## DECISION DELEGATED TO HEAD OF PLANNING

**Application No:** H08-0975-25      **Applicant:** Ms I Negoita  
**Proposal:** Erection of timber framed two storey dwelling & double garage, with associated off street parking & landscaping  
**Location:** Land To The North East Side Of Hedgefield Hurn Gosberton Spalding  
**Terminal Date:** 21st January 2026

Drawing Title:
PROPOSED GARAGE PLAN & ELEVATIONS

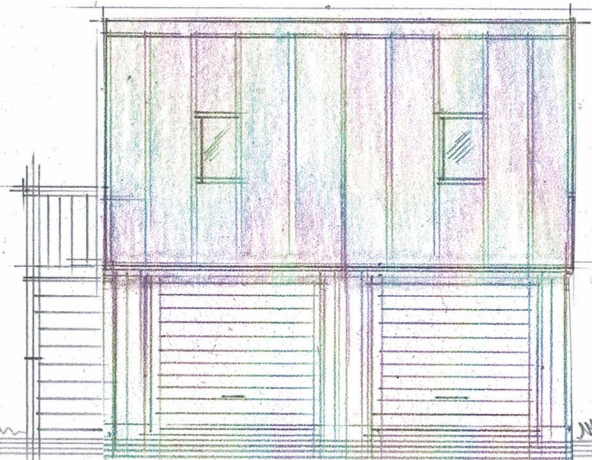
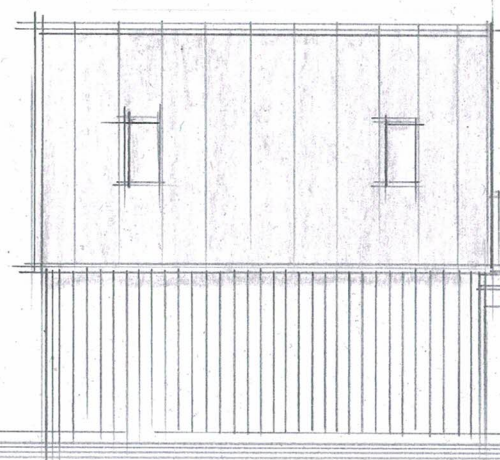
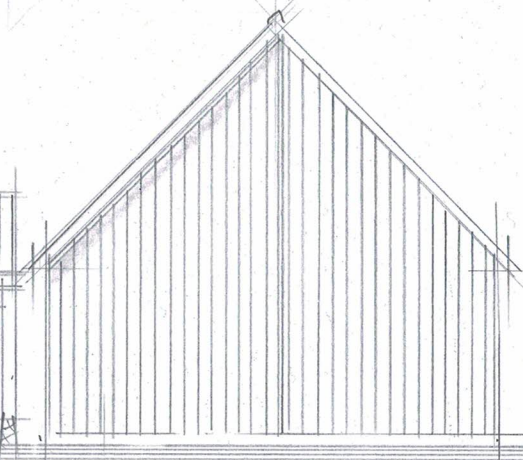
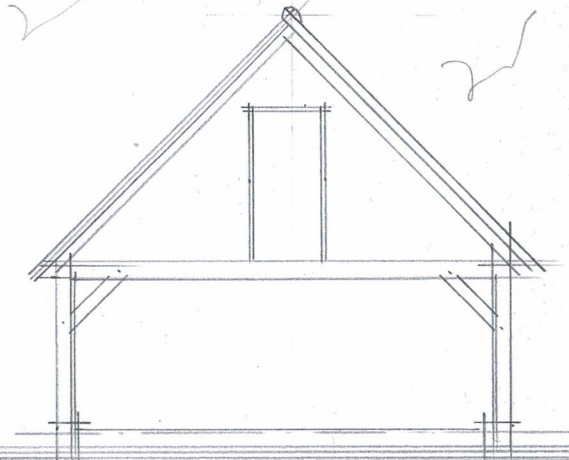
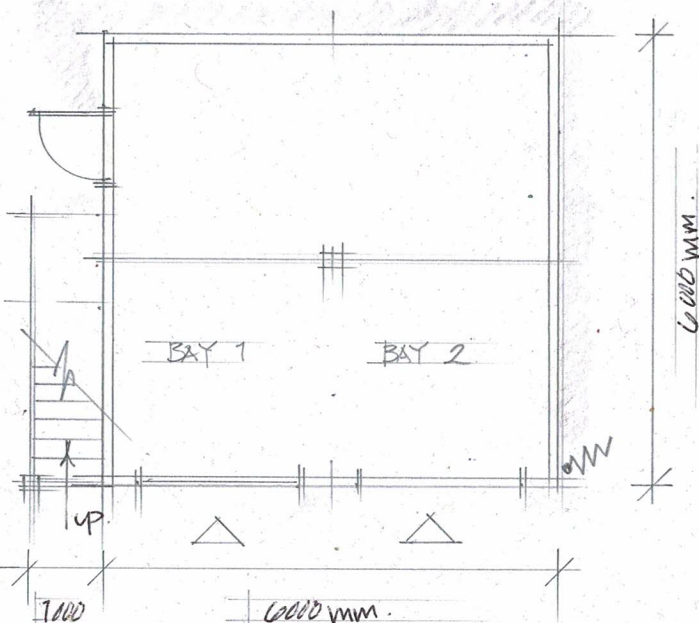
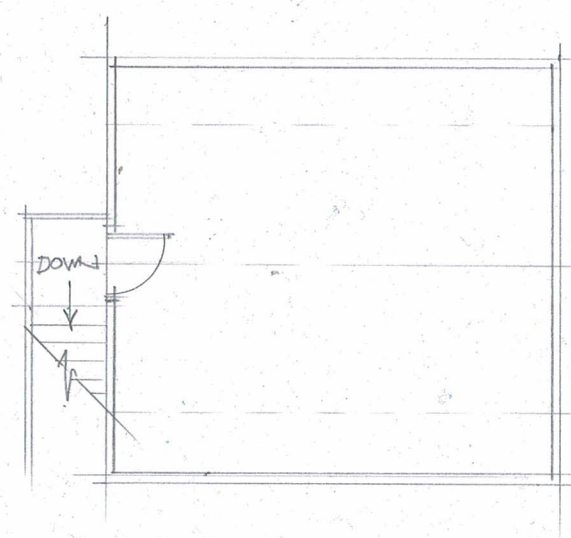
The garage is proposed to measure 6m by 6m with a gable end roof form, measuring 5.8m in height up to its ridgeline and 2.5m in height up to its eaves. The external materials are unclear; however, it appears that the building is proposed to feature timber cladding. An external stairway is proposed to allow access to the first floor within the garage.

BLOCK PLAN.  
DWA. REF : 100/2028/2025  
SCALE : 1:500 @ A4.

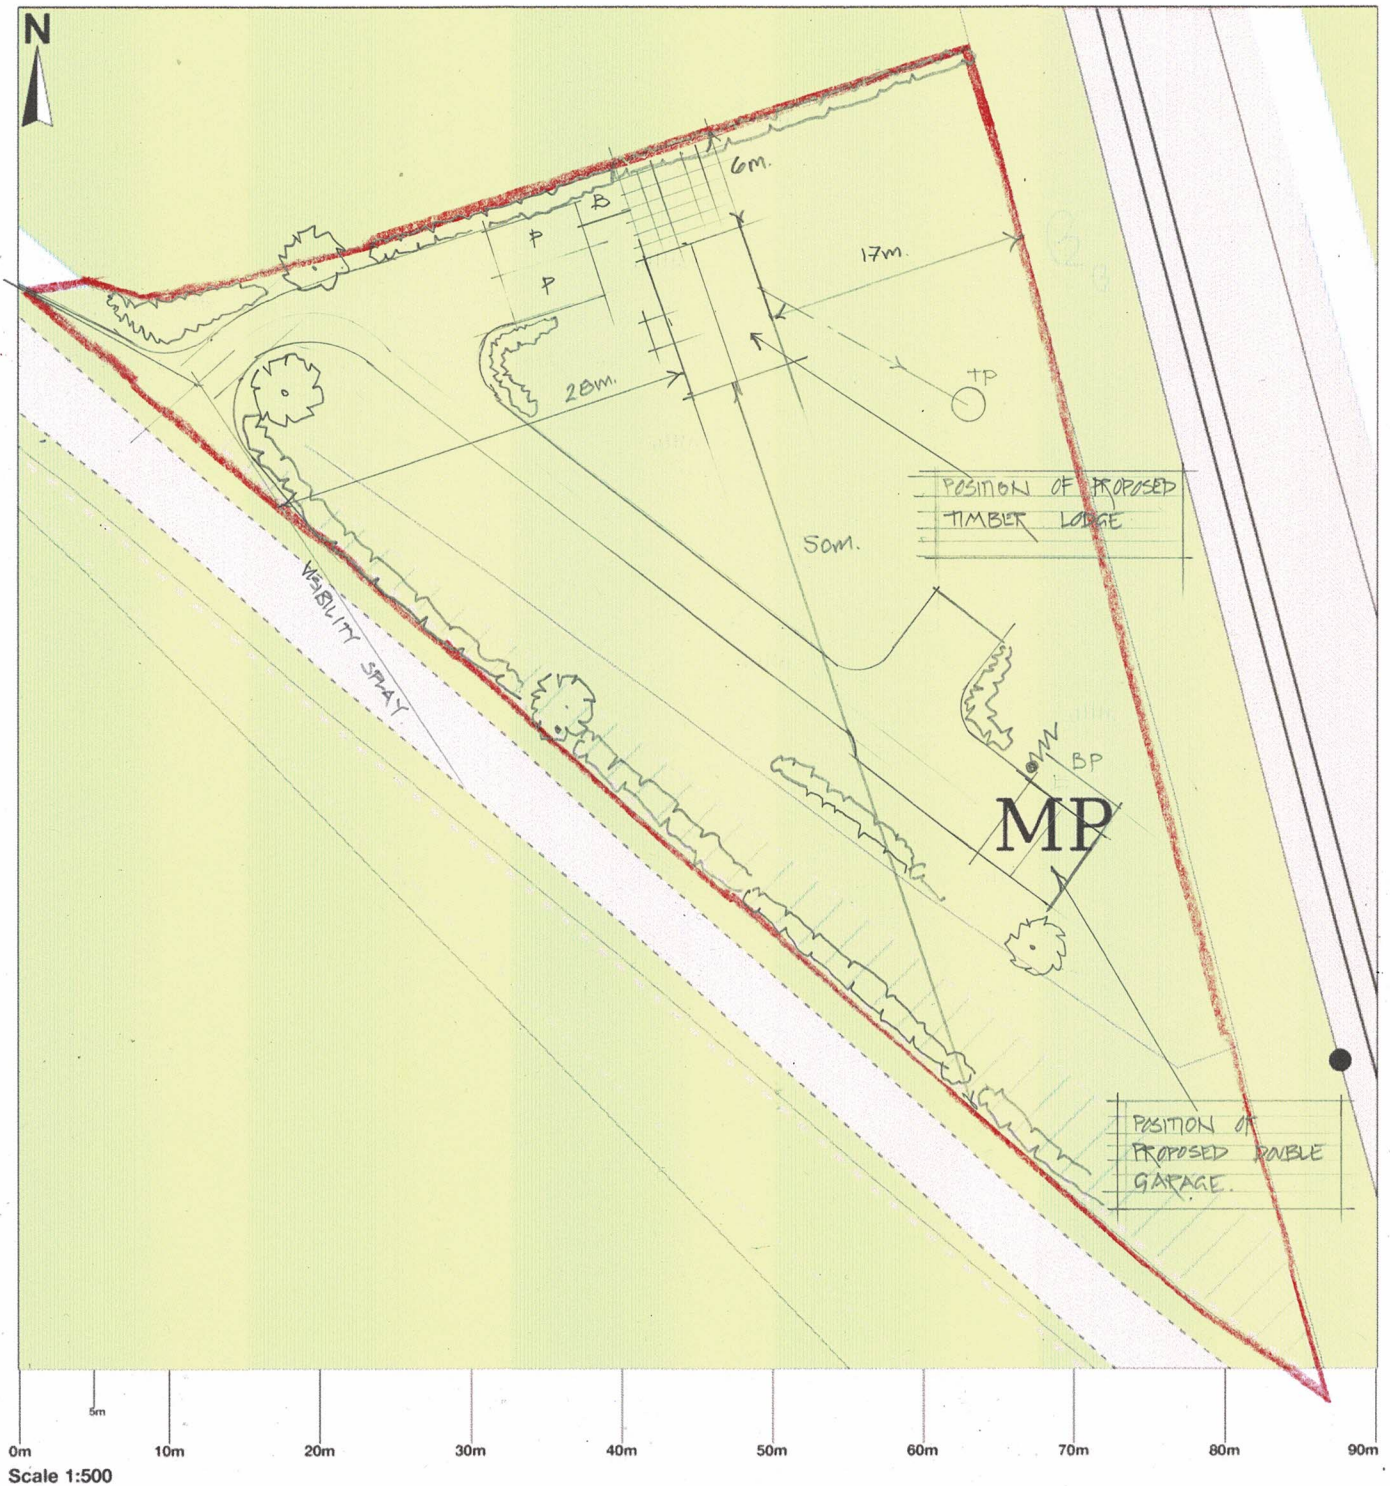
*-Environmental:* In environmental terms, the proposal would not provide a net gain in biodiversity as the applicant considers that the proposal would be exempt as the dwelling is for a self-build dwelling. Some planting is proposed within the site plan; however, most of this appears to be existing planting. Beyond this, the development of a residential dwelling, on otherwise undeveloped land, has an evident detrimental environmental impact.

The site itself is relatively flat; however, there is a landscape bund located to the north. The height of the bund is unconfirmed nor is it referenced on the submitted site plan. It appears that the bund is approximately the same height as close boarded timber fencing which has been erected along the northern edge of the site. There are various shrubs and trees around the edges of the site.

Proposed North-West Elevation

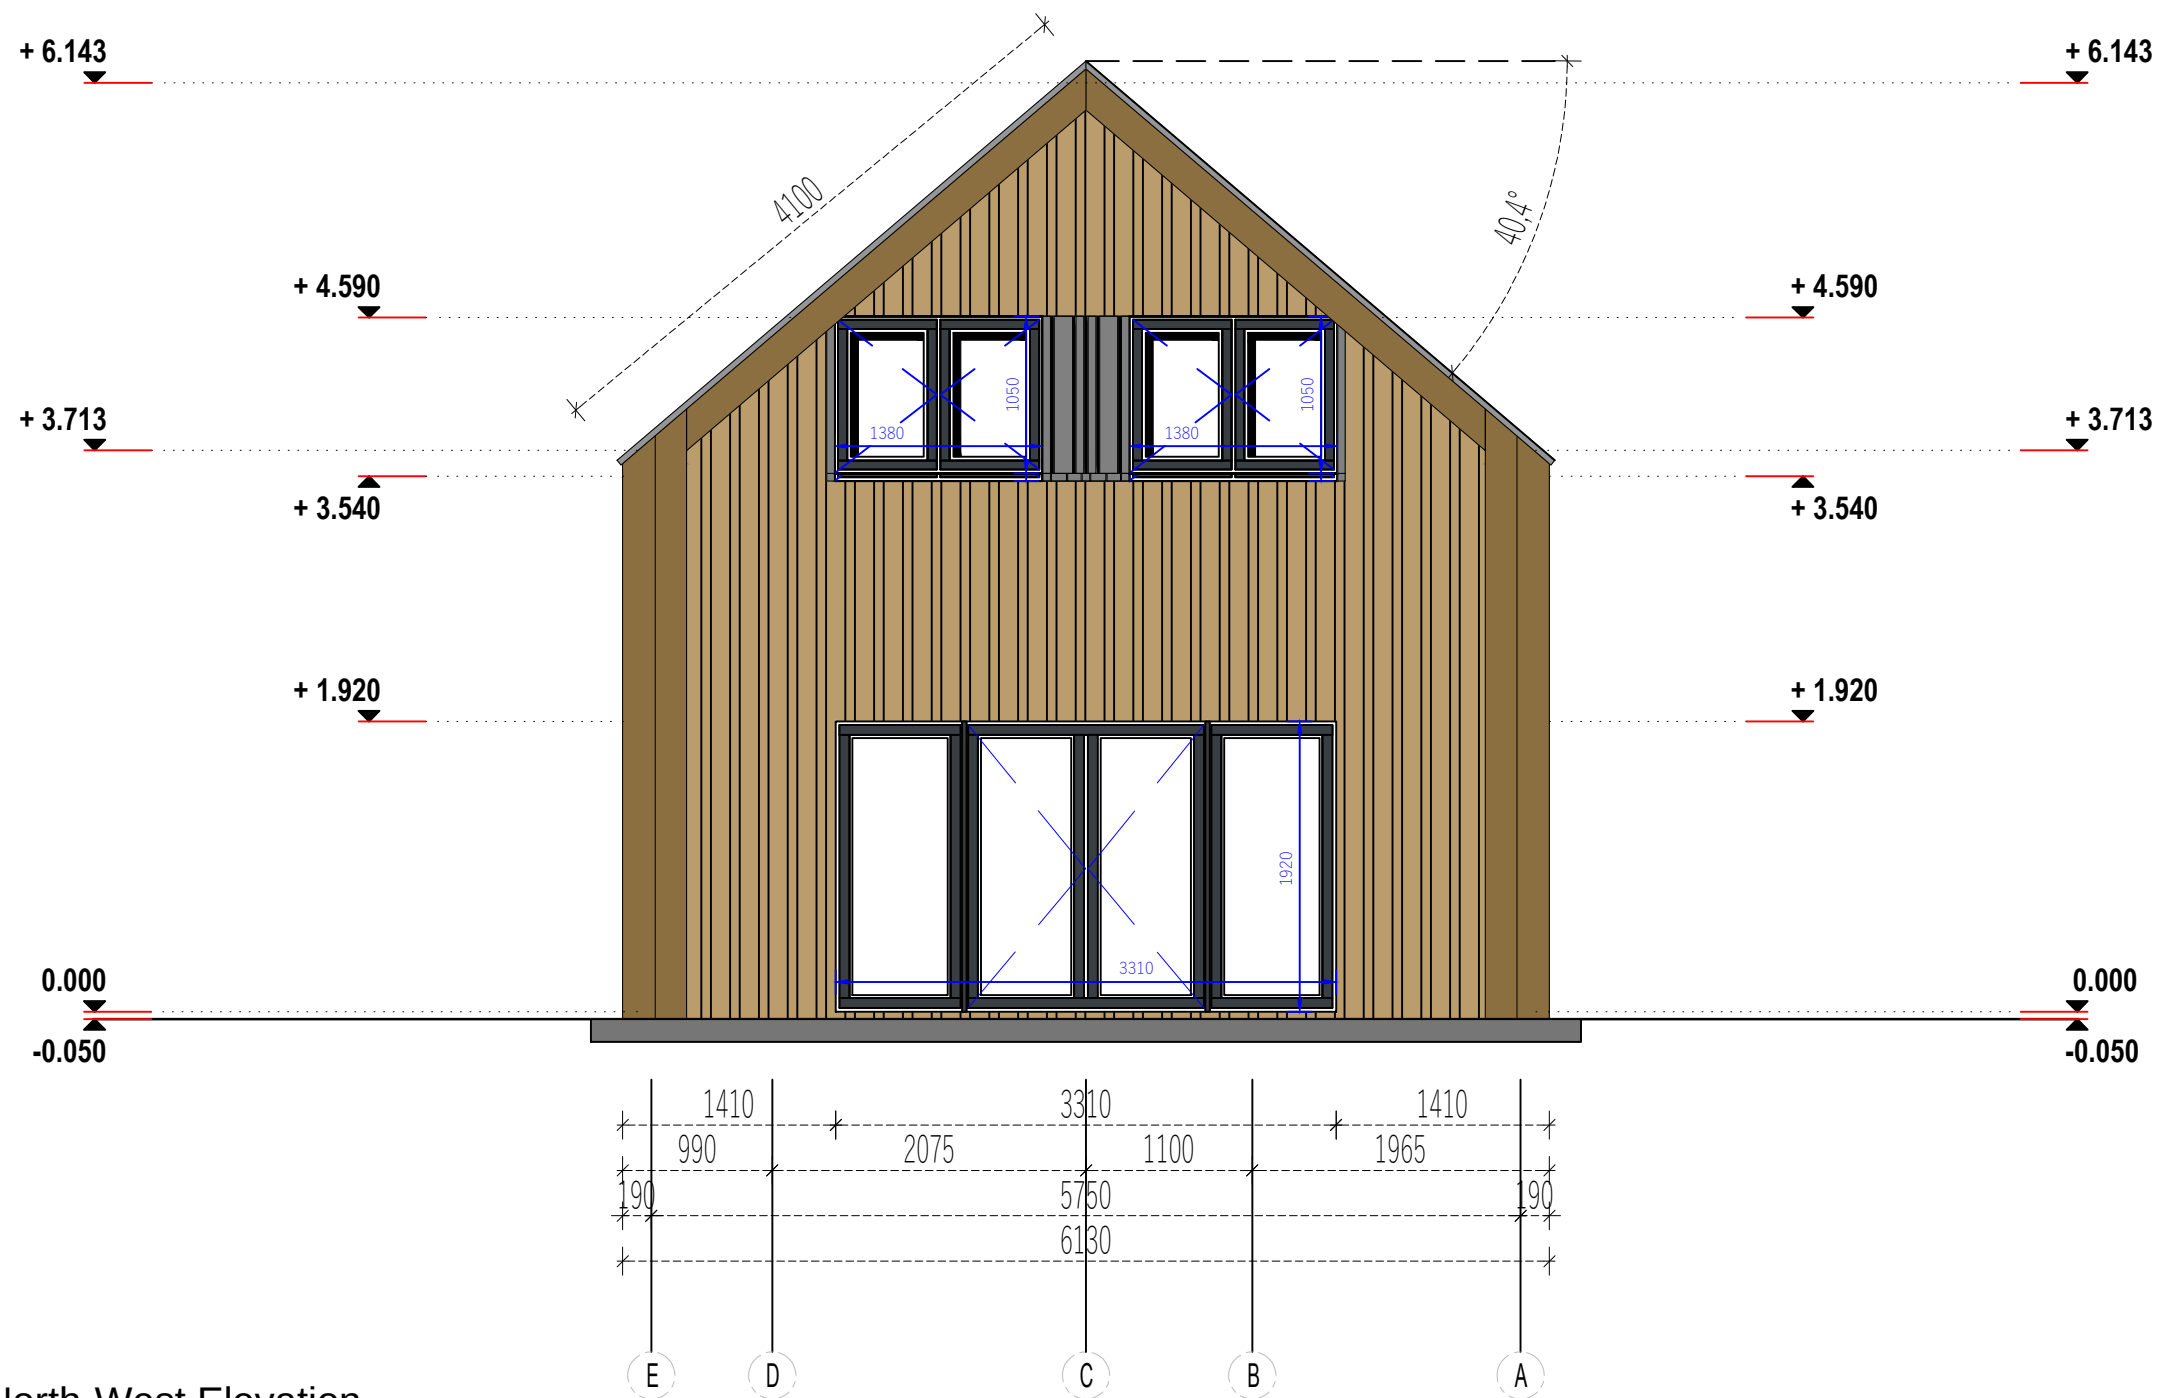
The dwelling is proposed to measure 9.68m by 6.13m, featuring a gable end roof form that would measure 6.3m in height up to its ridgeline and 3.77m in height up to its eaves. The proposed materials are set out within the application form rather than on the submitted elevation plans and include the following:

There are areas of darker cladding proposed sporadically on the elevations. It is presumed that these areas are proposed to feature cladding; however, the plans do not clarify this.
